Application number: 2021/90800	
What is the application for?:	Redevelopment and change of use of former mill site to form 19 residential units
Address of the site or building:	Hinchliffe Mill, Water Street, Holmbridge, Holmfirth, HD9 2NX
Postcode:

Type of comment: An objection	
Do you wish your comments to be published on the website anonymously?	Yes
<p>Although on principle I support the development of the mill building and the land behind the mill, as I would much prefer it to be utilised to compliment the area and to maintain the natural landscape and wildlife of the mill pond rather than allow the whole centre point of the village to be left to go to further ruin, I cannot support the amended plans as they do not address key issues.</p> <p>Over intensification of the site is still a major issue as although the number of houses has been reduced from 24 to 19, 19 being the indicative maximum capacity allocated for the development of the site HS190 in the Kirklees Local Plan, the local plan does not identify the size of dwellings and with the majority of the proposed dwellings being large 3 and 4 bedroom properties, the volume of cars will be far more than a development of 19 2 b

HOUSE TYPE : UNIT 2

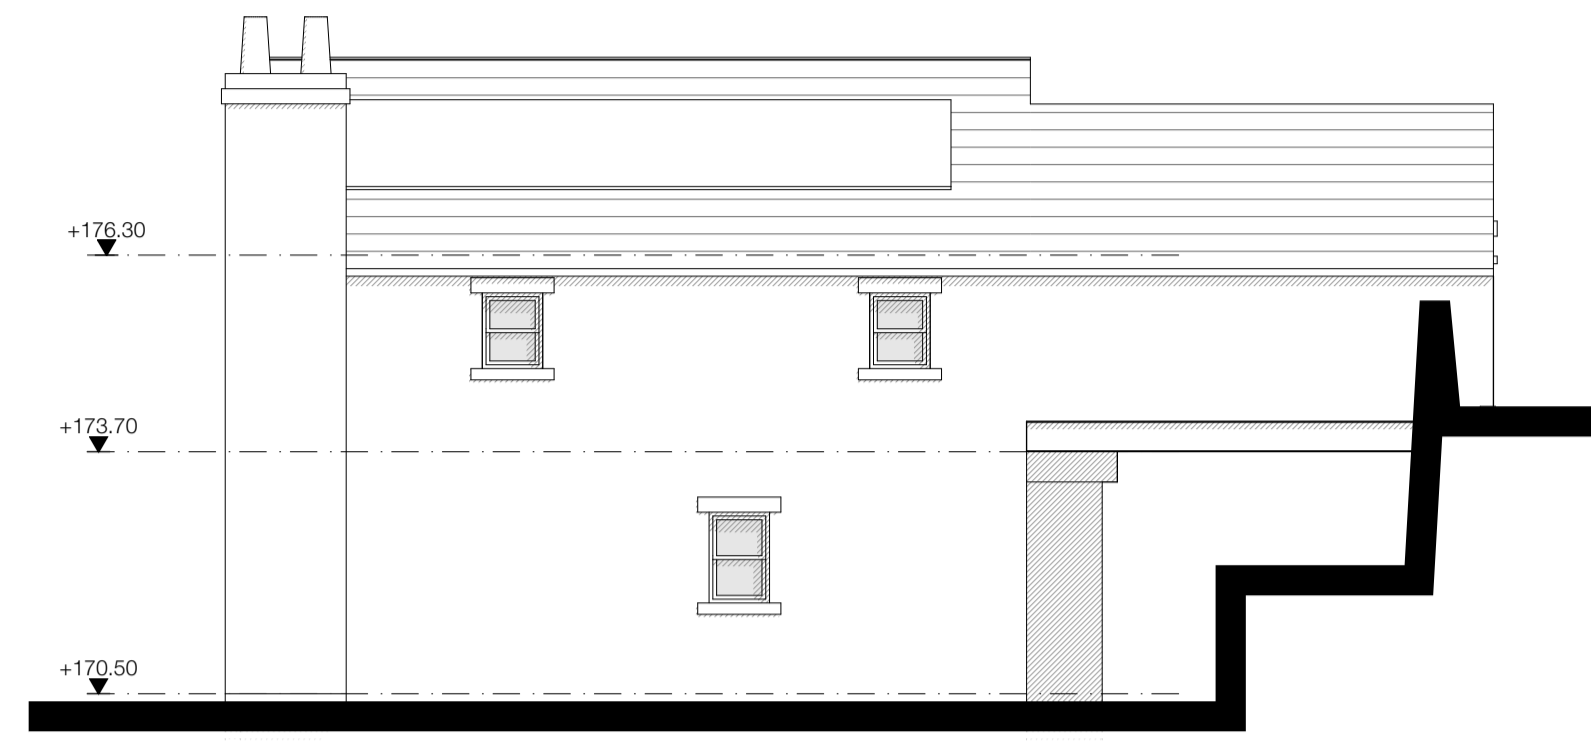
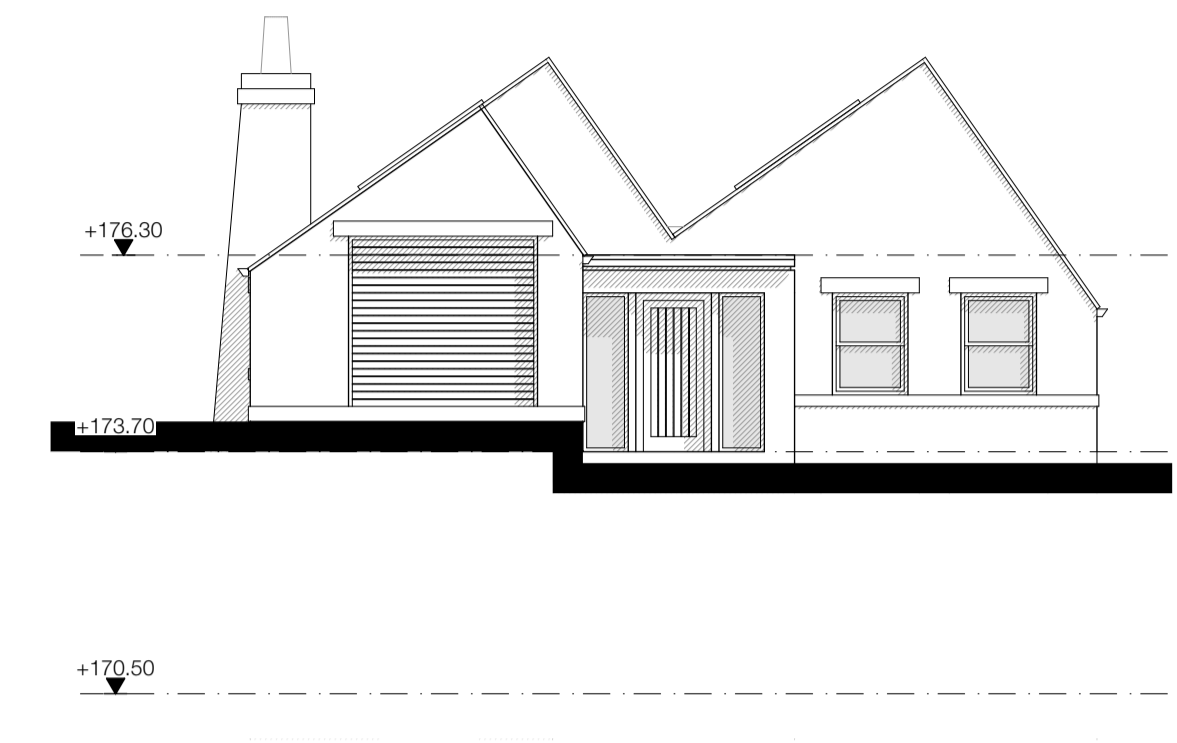
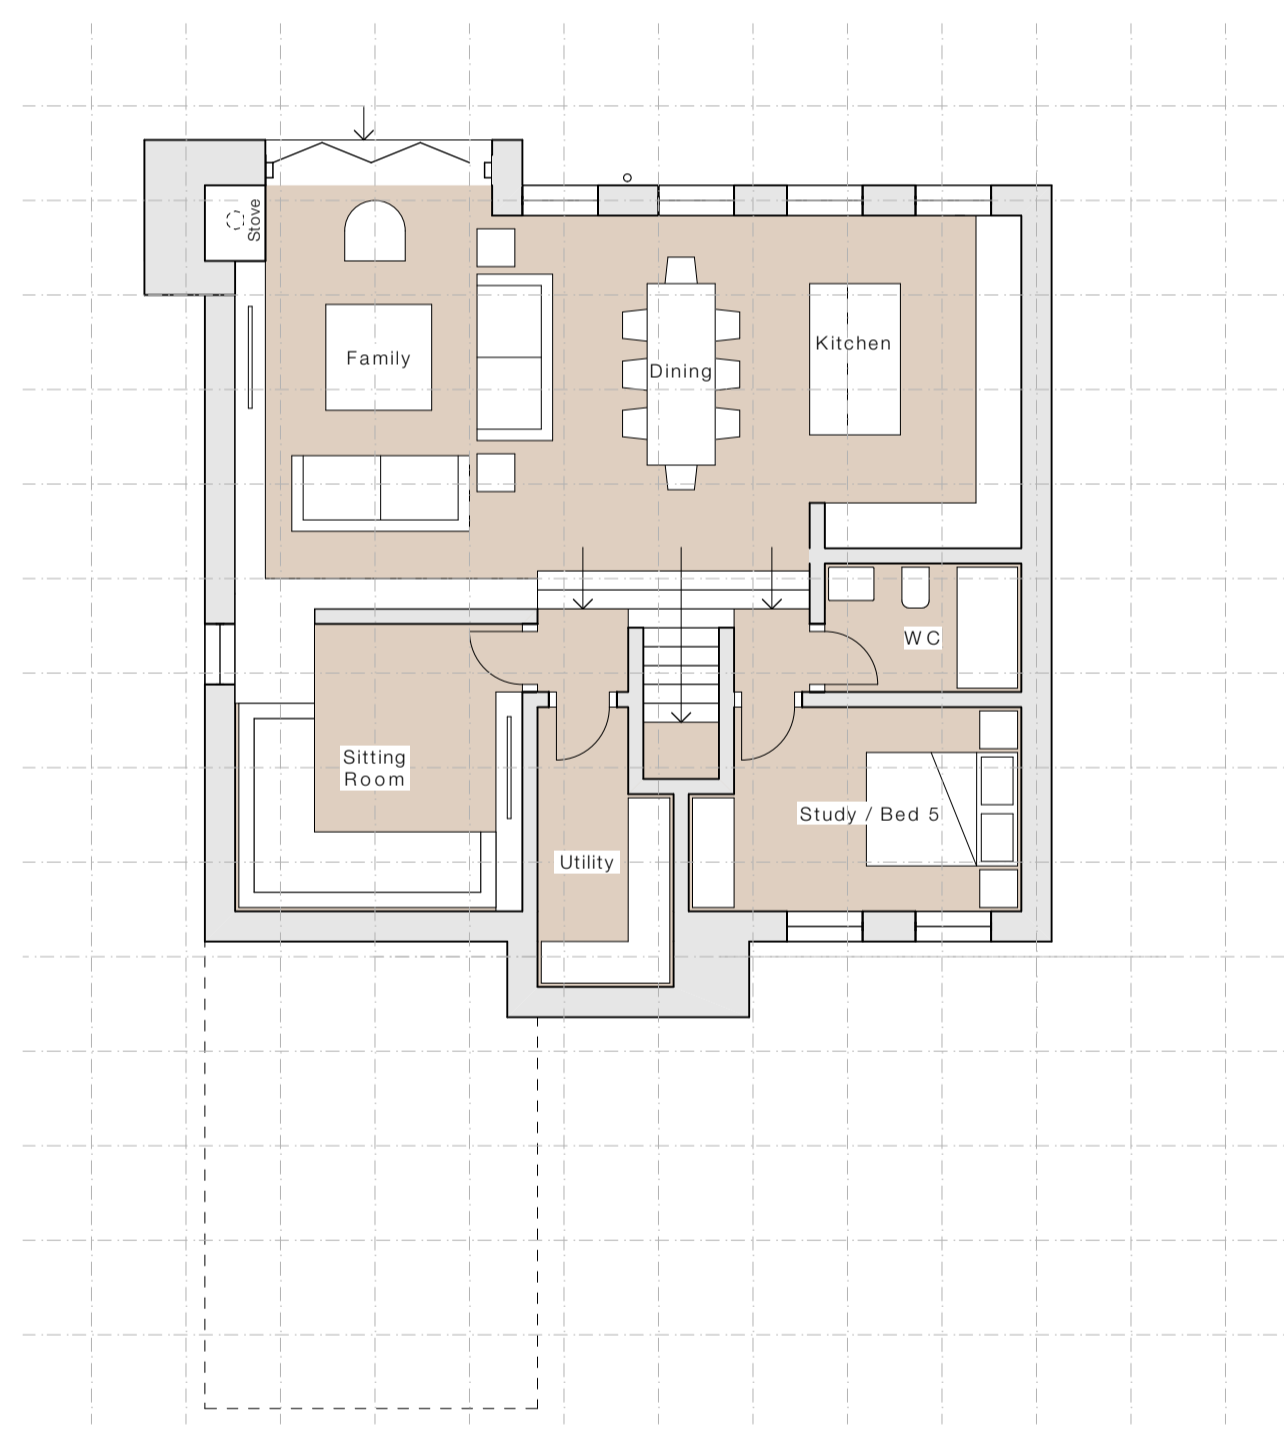
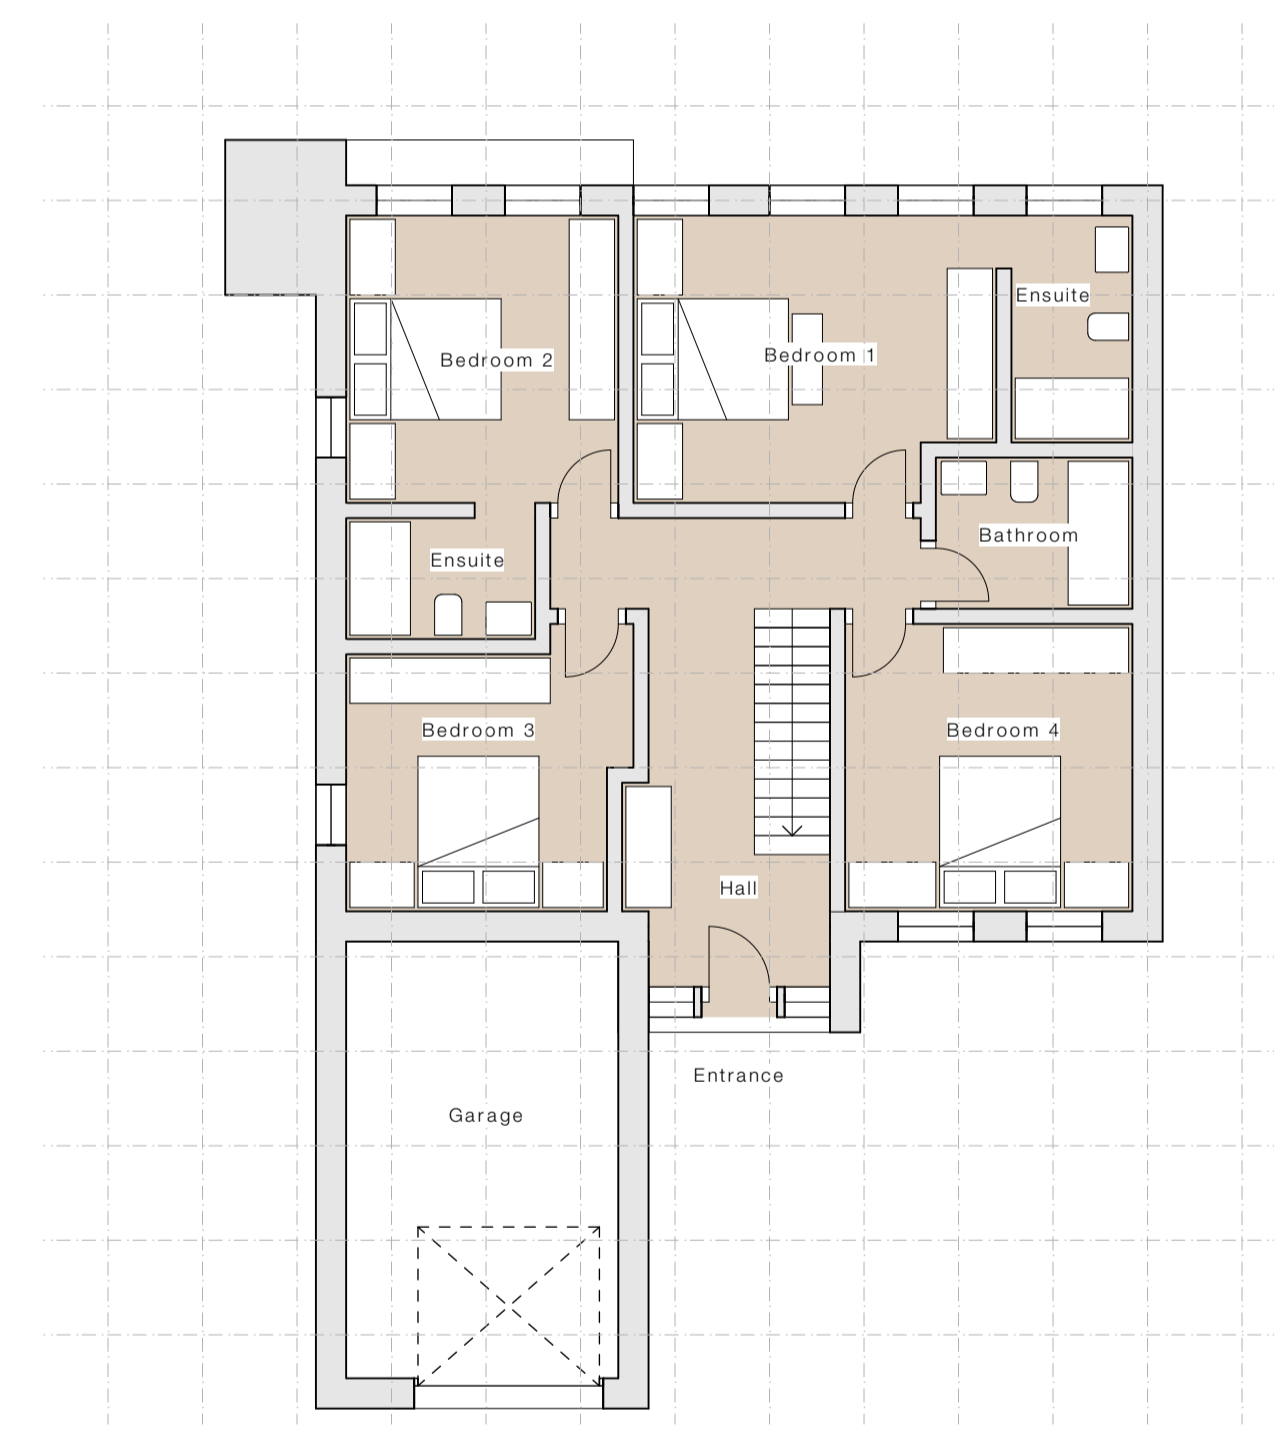
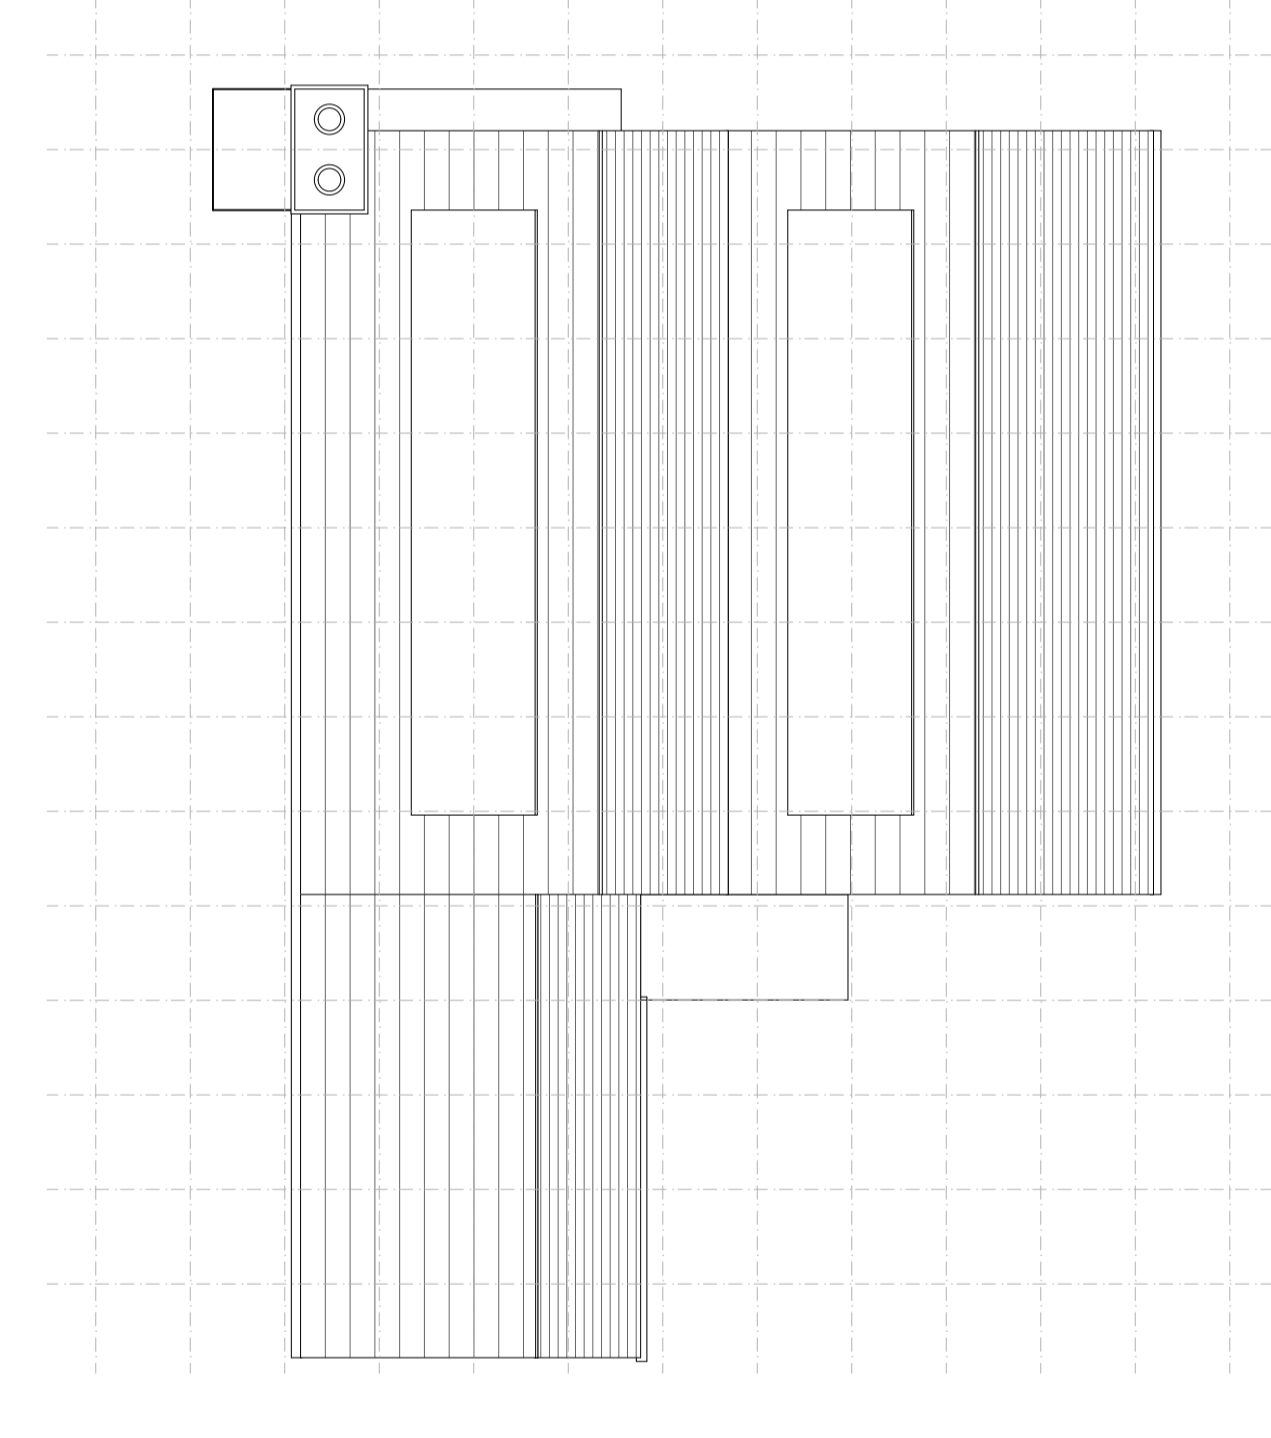
The scale and massing of plot 1 & 2 directly adjacent to the mill building, overlooking the dam are unduly dominant and out of scale with the heritage Class 3 asset mill building which would lose its local prominence, adversely affecting its village-scape merit and immediate setting. The 5 dwellings on the hillside above the mill complex are in a location that will dominate the village. They will in no way blend in or be hidden in the valley bottom as the majority of other dwellings in development will be. Historic England submitted concerns that previous plans presented a 'domestic' feel, at odds with the industrial character of the site which would not preserve or enhance the special interest of surrounding designated and non-designated assets and would be harmful to the character and appearance of the conservation area, and consequently cannot be supported. Complete removal of plot 1, or further reduction in scale and massing of plot 1 & 2 is required. Further design consideration is needed in keeping with the context of the industrial setting and surrounding properties in this conservation area.
